Our Case Number: ABP-318540-23

Re: 10 year planning permission for the proposed Open Cycle Gas Turbine (OCGT) power plant fuelled by Hydrotreated Vegetable Oil (HVO) and associated site works at Tarbert Island, Tarbert, Co. Kerry. (www.ssetarbertnextgen.com)

Date: 1st February, 2024

Re: Strategic Infrastructure Development - ABP- 316229 – Proposed 350MW Low Carbon Open Cycle Gas Turbine (OCGT) fuelled by hydrotreated vegetable oil, administration building and workshop, and ancillary plant and infrastructure in Tarbert Power Station, Tarbert, Co. Kerry

A-A | NORTH WEST ELEVATION
1:150

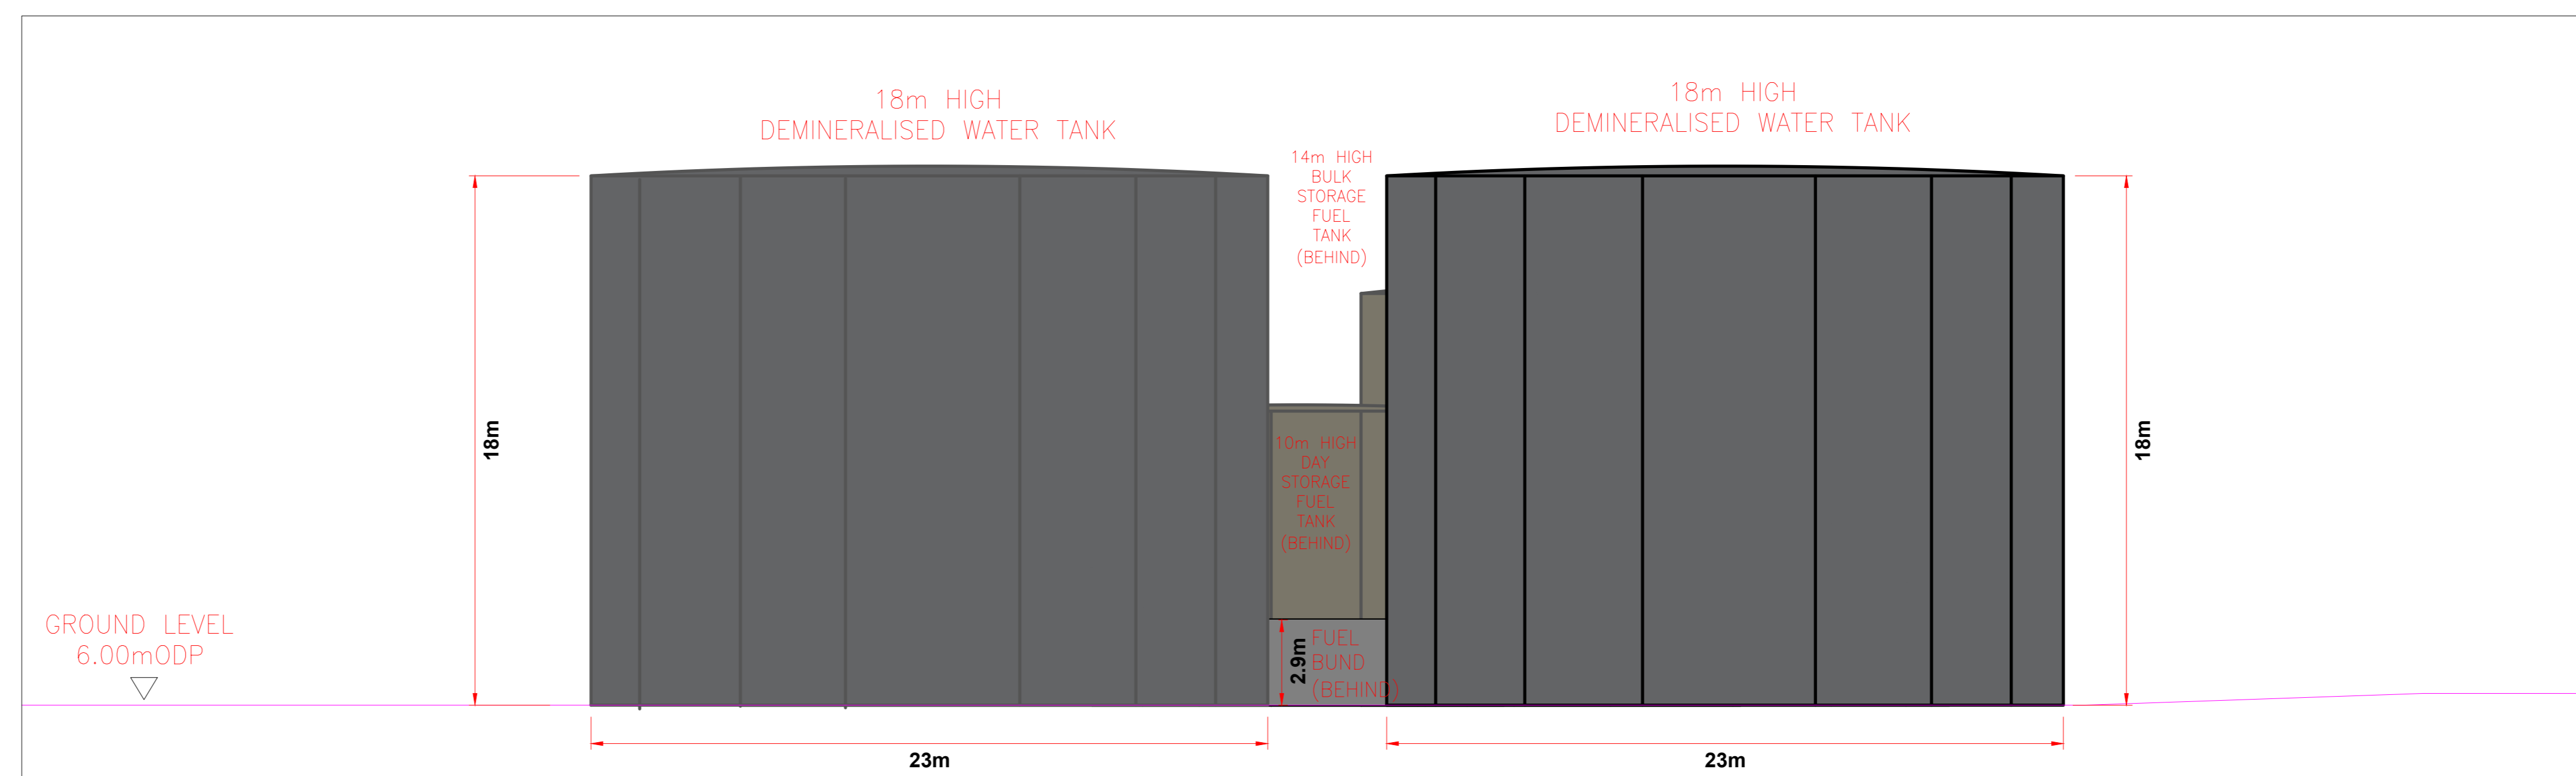
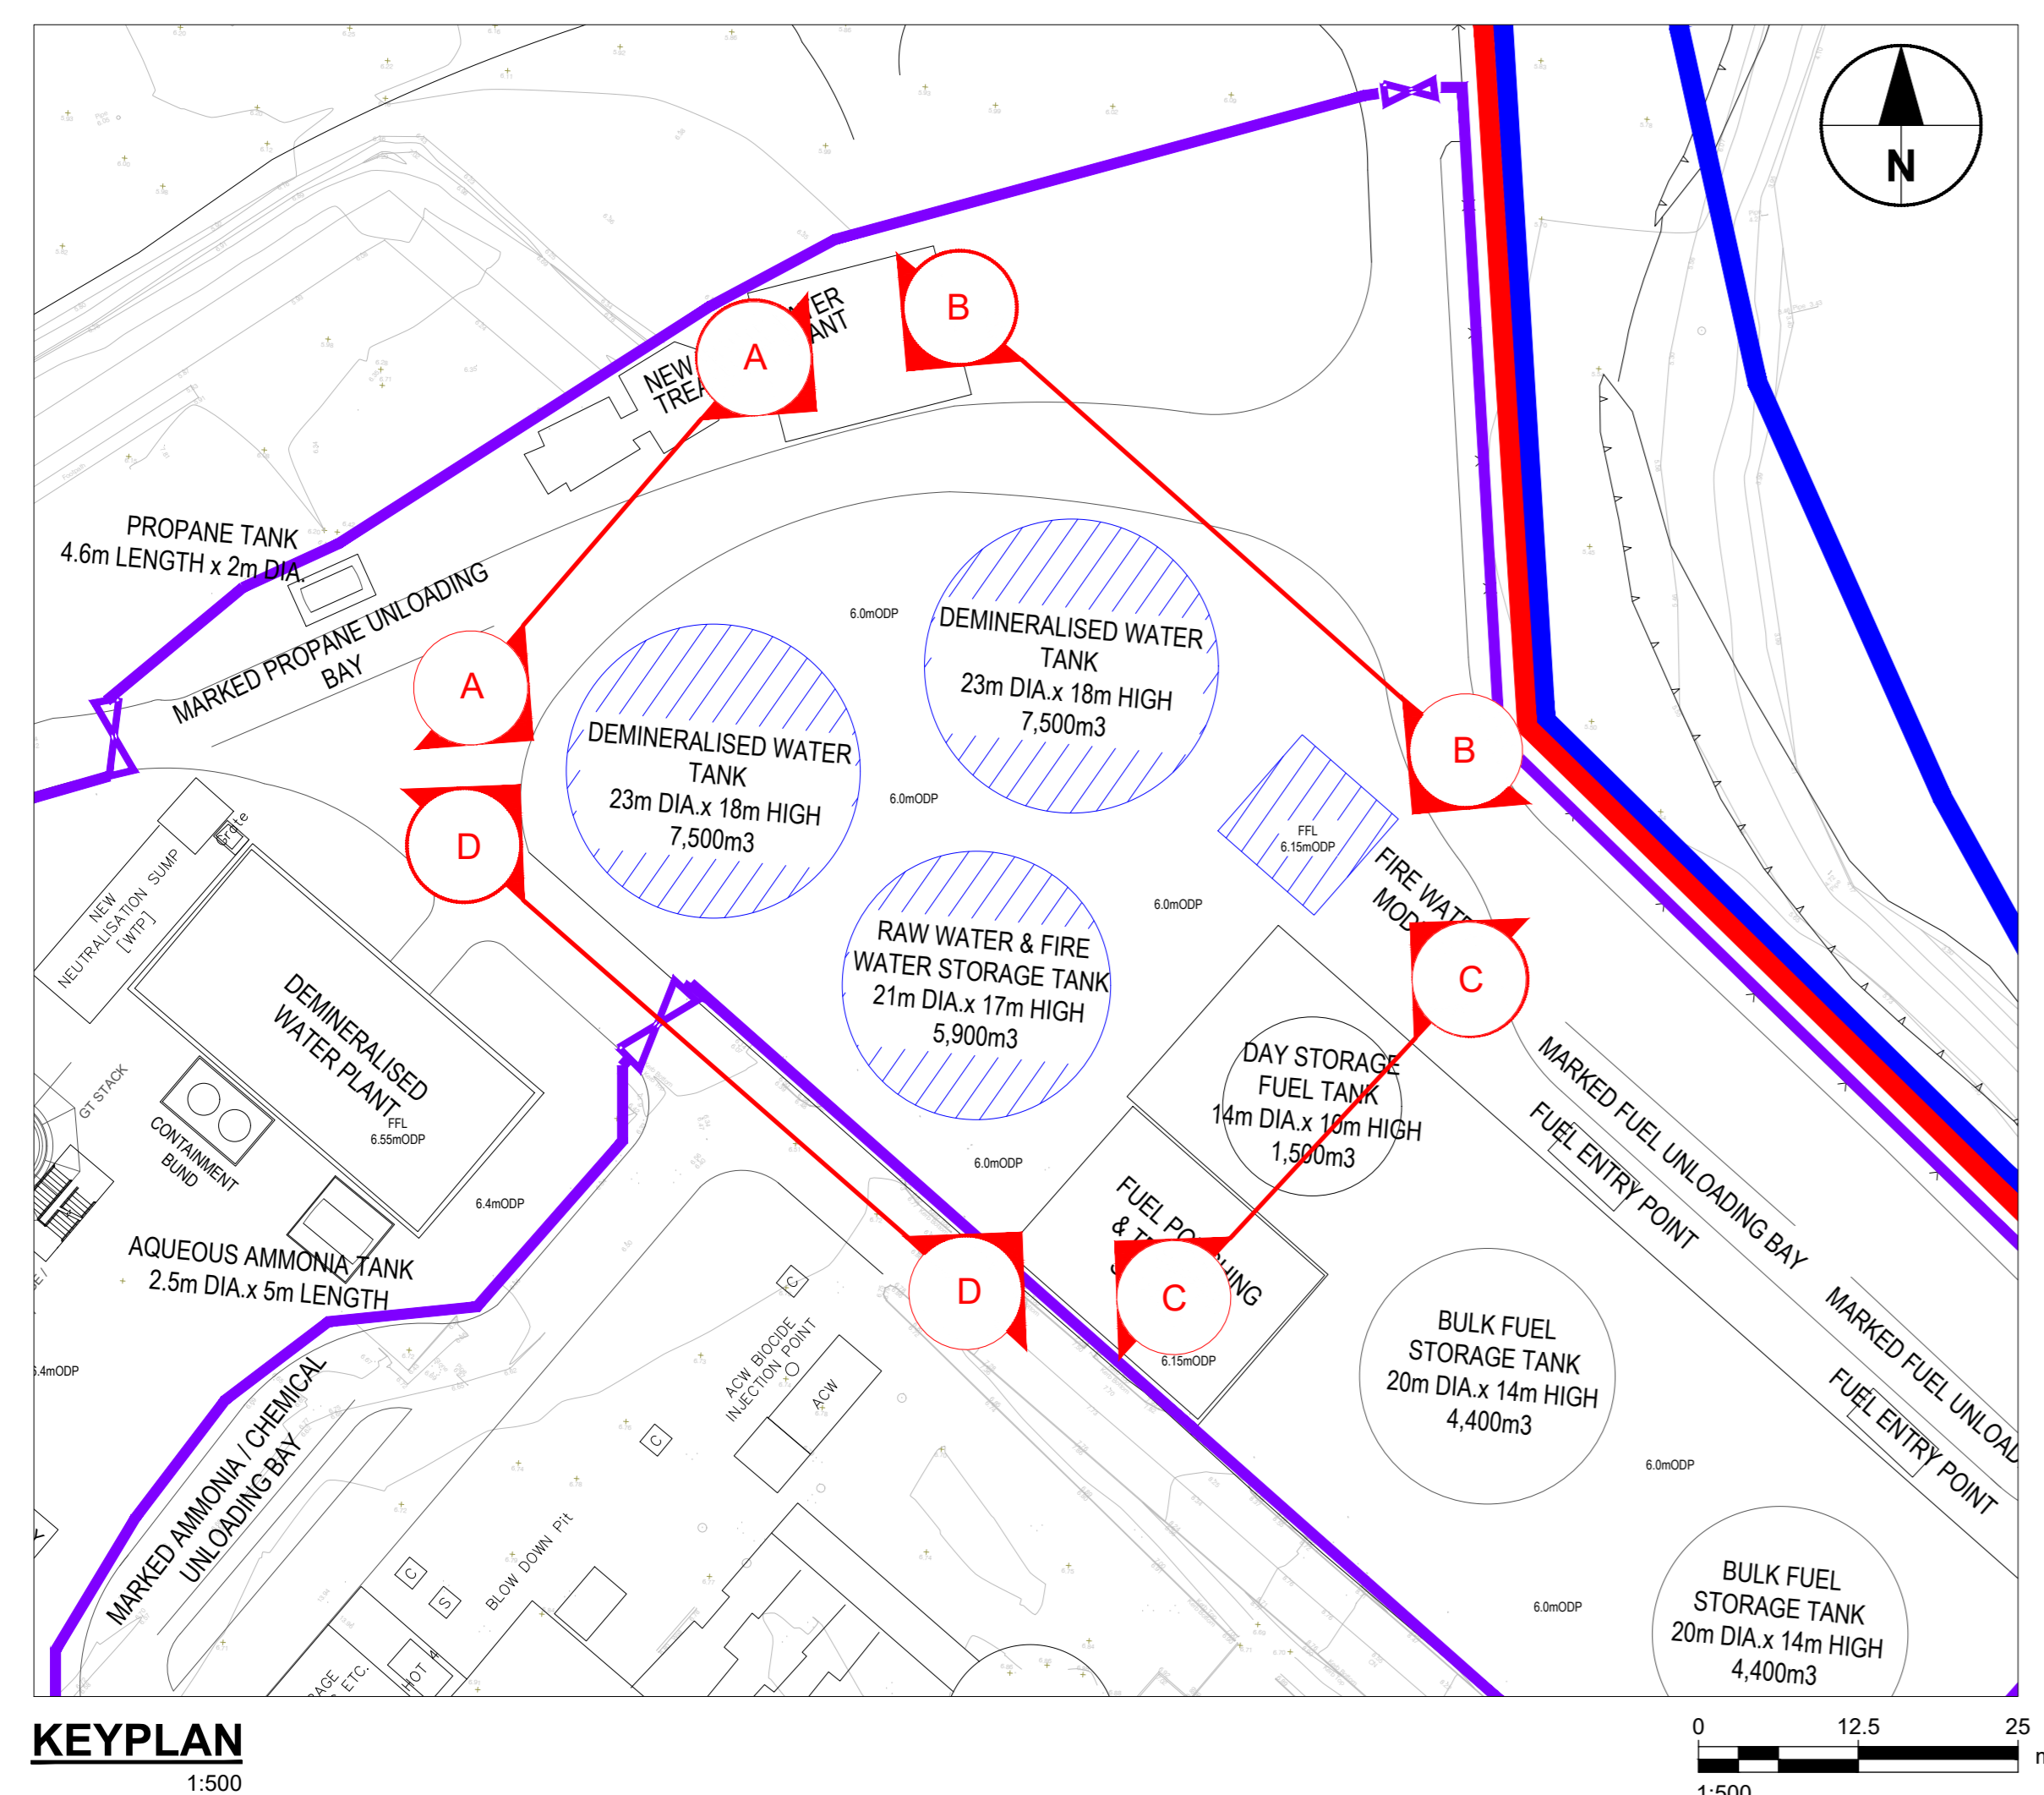
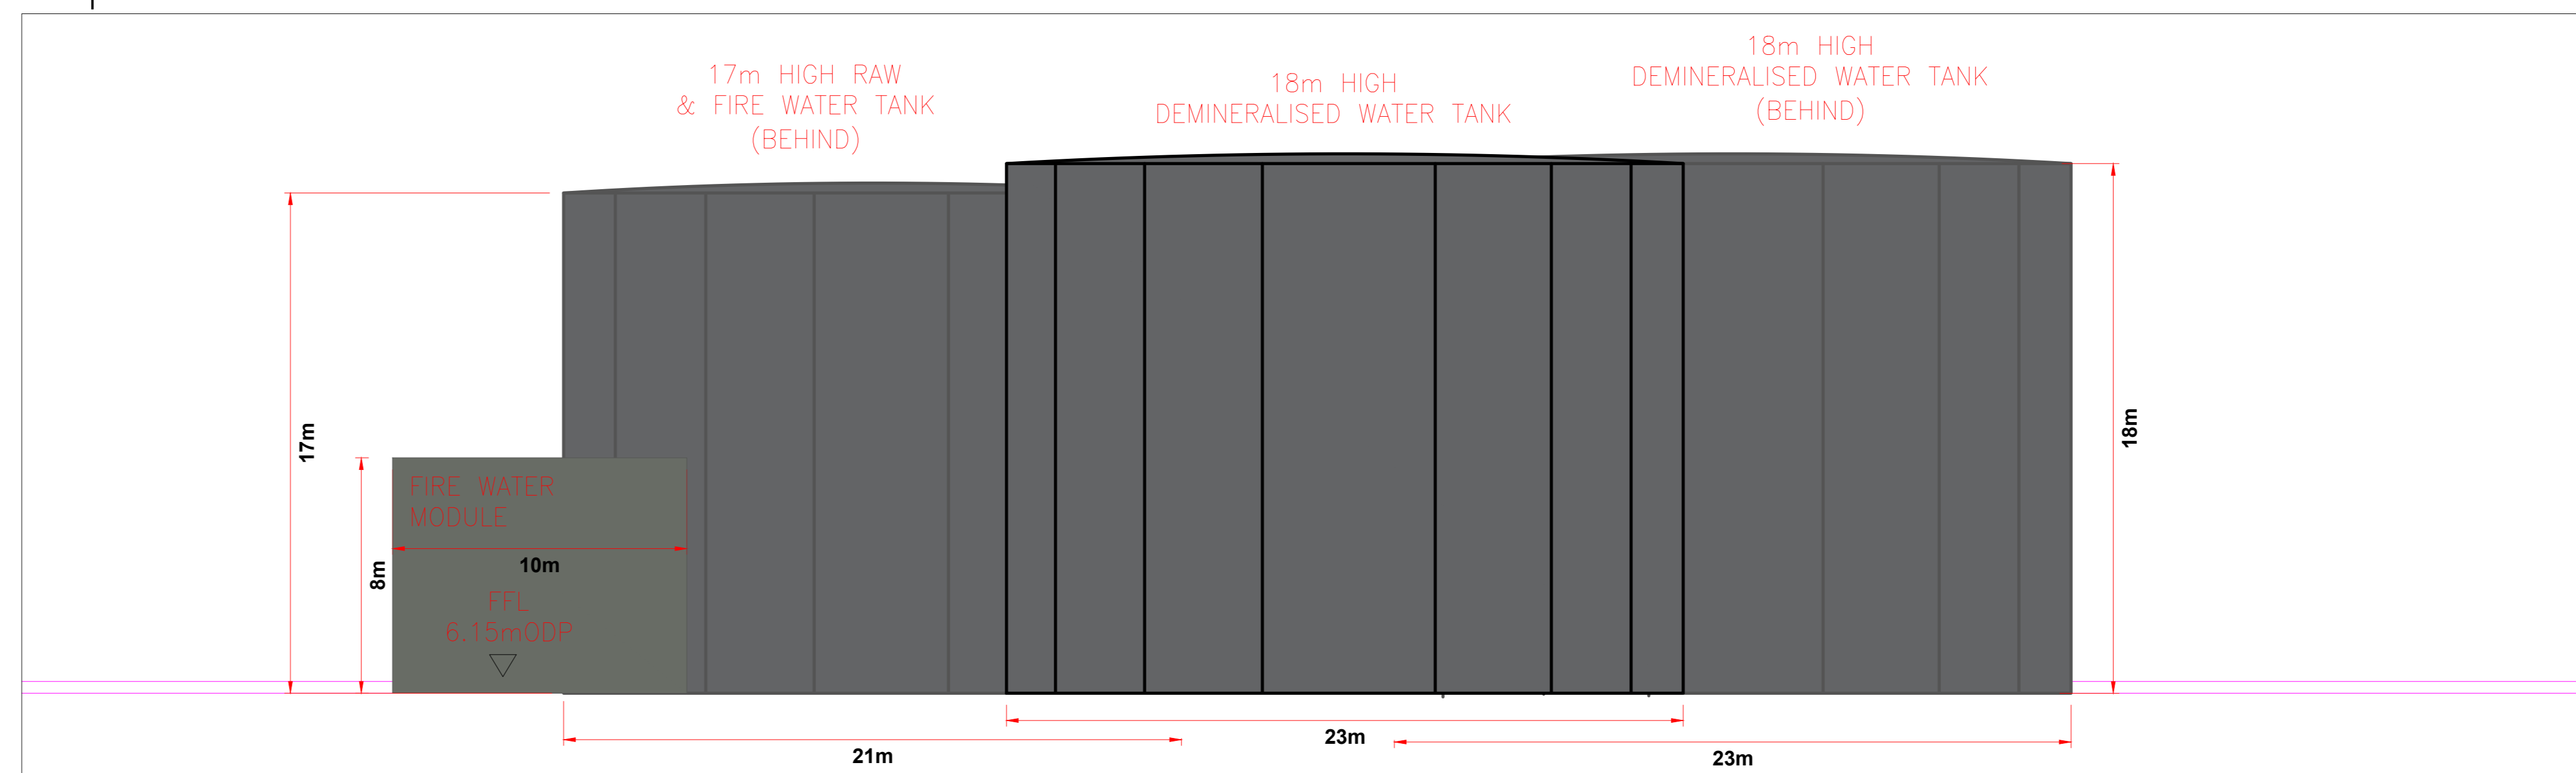
It is noted in Section 5.2.5 'Water Supply' in the Environmental Appraisal Report that it is expected when in operation, the proposed development will require up to c.150m³ per hour of demineralised water. Whilst UÉ notes the overall proposed reduction in water usages, the supply remains significant and volumes of this nature, in addition to the proposed firewater/water storage tank of approximately 5,900m³ will need to be considered as part of UÉ's feasibility assessment.

UÉ have subsequently been in contact with the Applicant's agent and have been provided with some further detail/ figures in terms of the proposed volumes of water usage. UÉ have some concerns with the figures being proposed, particularly what the peak flows might be and the potential impacts on the reservoir storage as well as the impacts on existing watermains and networks.

- Calculations including peak and seasonal water demand profiles
- To include:
 - Details for the proposed 2 no. Demineralised water storage tanks
 - Details for raw water and fire water storage tank
- Detailed and current demand profiles to inform supply and hydraulic modelling

- The applicant shall engage with Uisce Éireann by submitting a pre-Connection Enquiry (PCE) to assess feasibility of connection to the public water / wastewater infrastructure.
- The outcome of the PCE is to be submitted as a response to Further Information Request.
